Our Ref: BR/236/19/L
Your Ref:

Application for Listed Building Consent for Alterations, Extension or Demolition of a Listed Building

Development Proposed single storey side extension including demolition of existing garden room.
Location Culver Cottage 37 Aldwick Road Bognor Regis

LOCATION & BLOCK PLAN
Dwg. No. 599-100

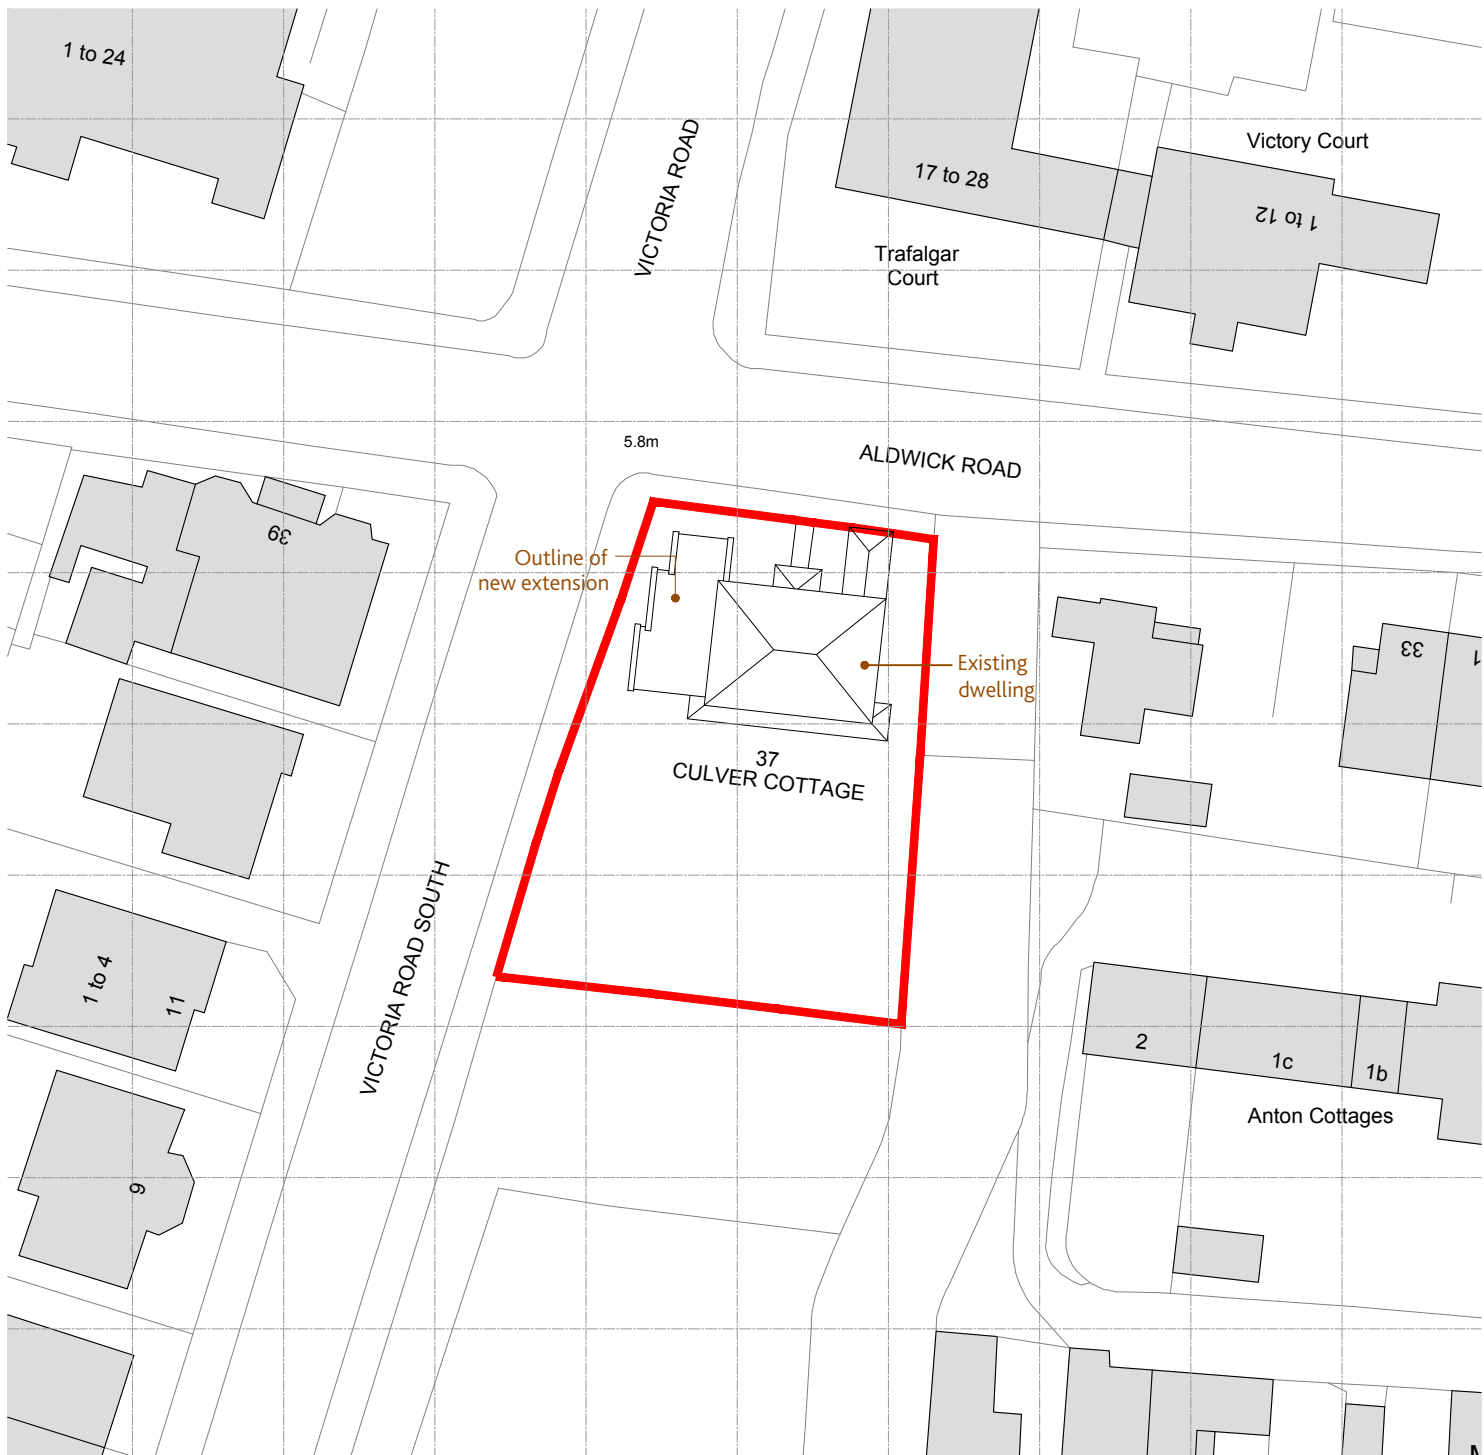
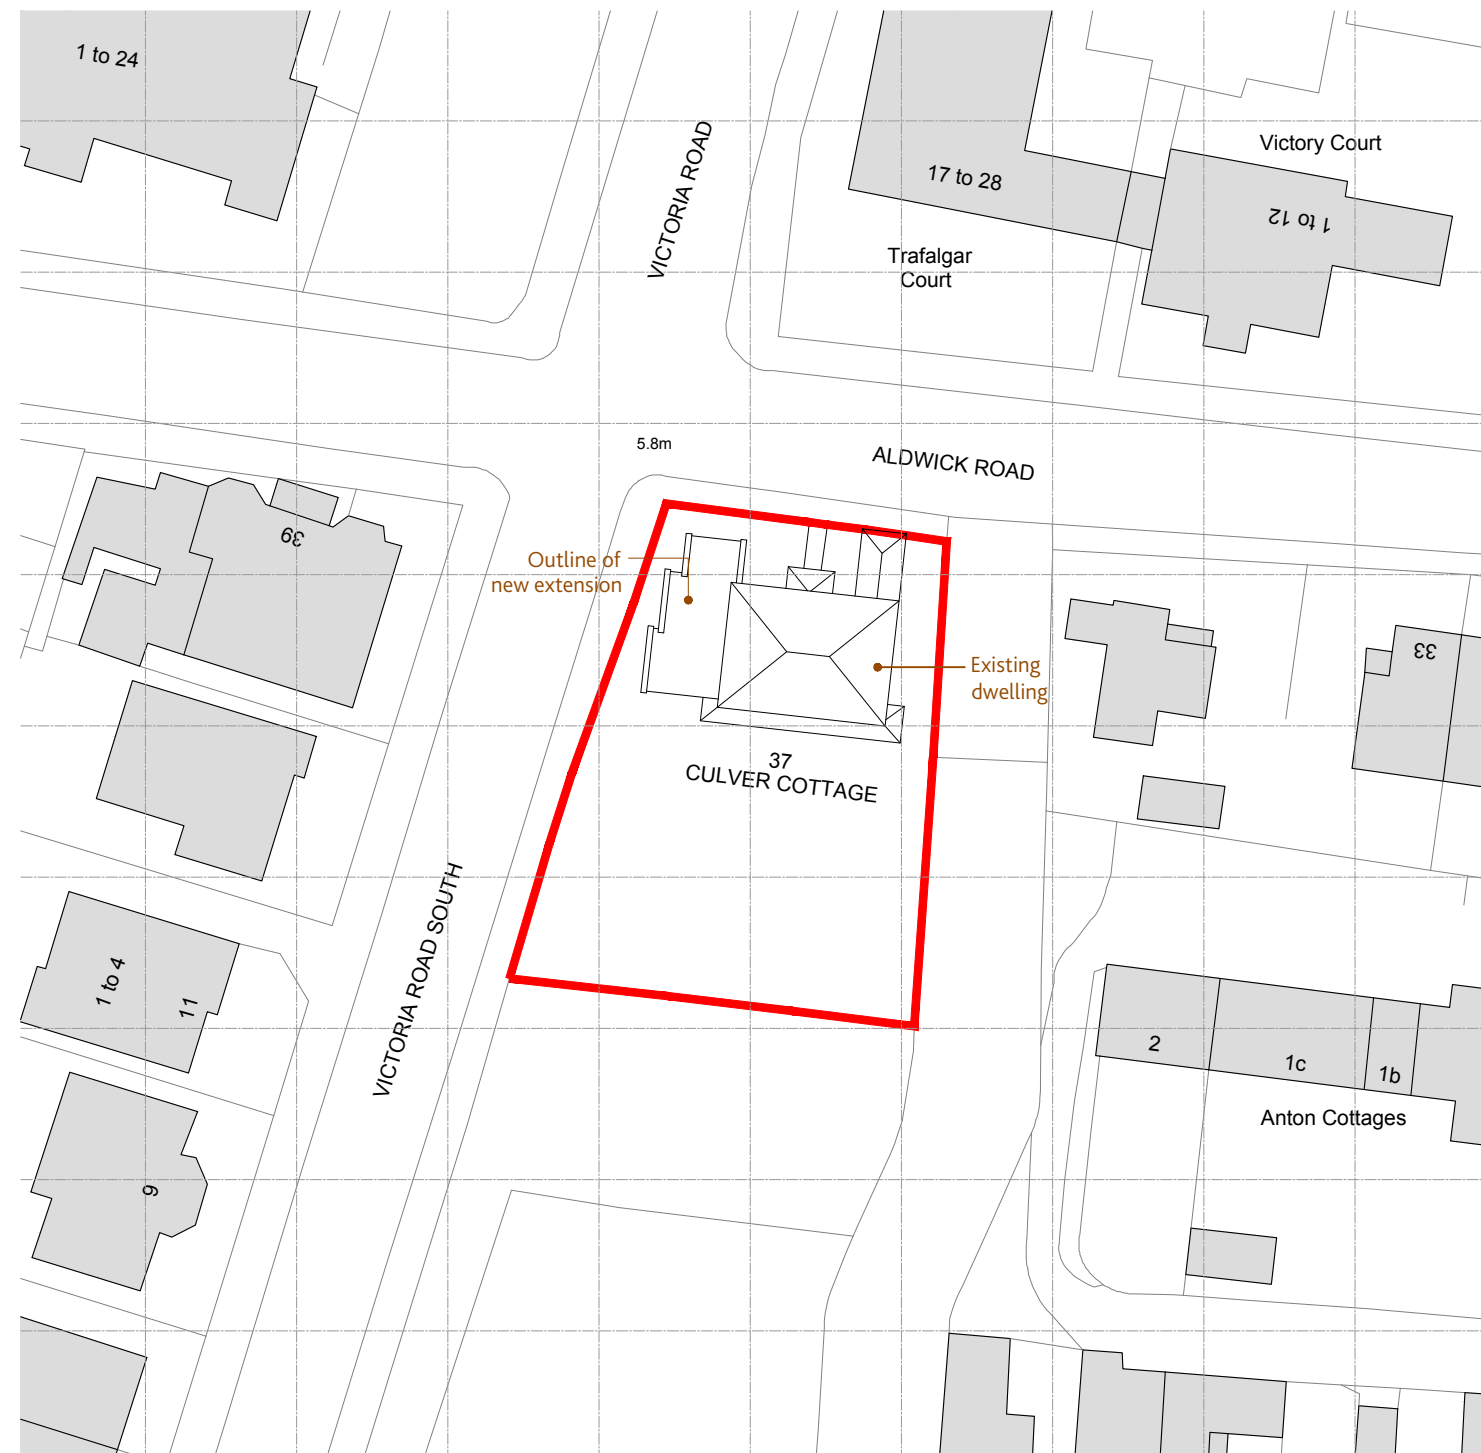
Block Plan

Please include dimensions on the block plan from the proposed extensions to all site boundaries.
